Permit Inspections

Harnett County

Permit Number: SFD2501-0066

Description: 59x38 sfd 3 beds 2 baths

Job	Truss	Truss Type	Qty	Ply	LGI HOMES\TAYLOR PLAN RF
72505106REP1	A5	Truss	3	1	Job Reference (optional)

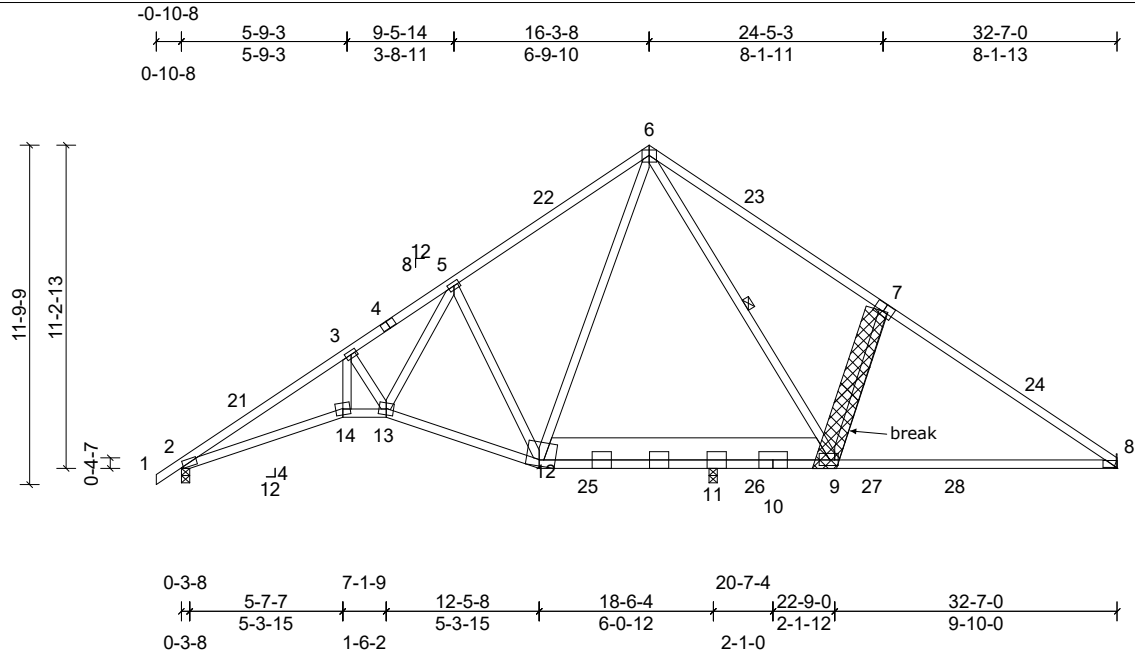
4/29/2025	4/29/2025	ROUGH IN	John B Kokoszka	DISAPPROVED	eTRAKiT Inspection Request
Notes: 4/28/2025 10:27 AM LGI Homes-NC, LLC Contact Name: LGI Homes-NC, LLC Site Address: 114 CAMP ROCK RD Phone: 9197953922 e-Mail: oliver.hudson@lgihomes.com 1. Missing each clip in laundry room, A22. A5 trust at attic access brokenOK to insulate as long as we can see everything
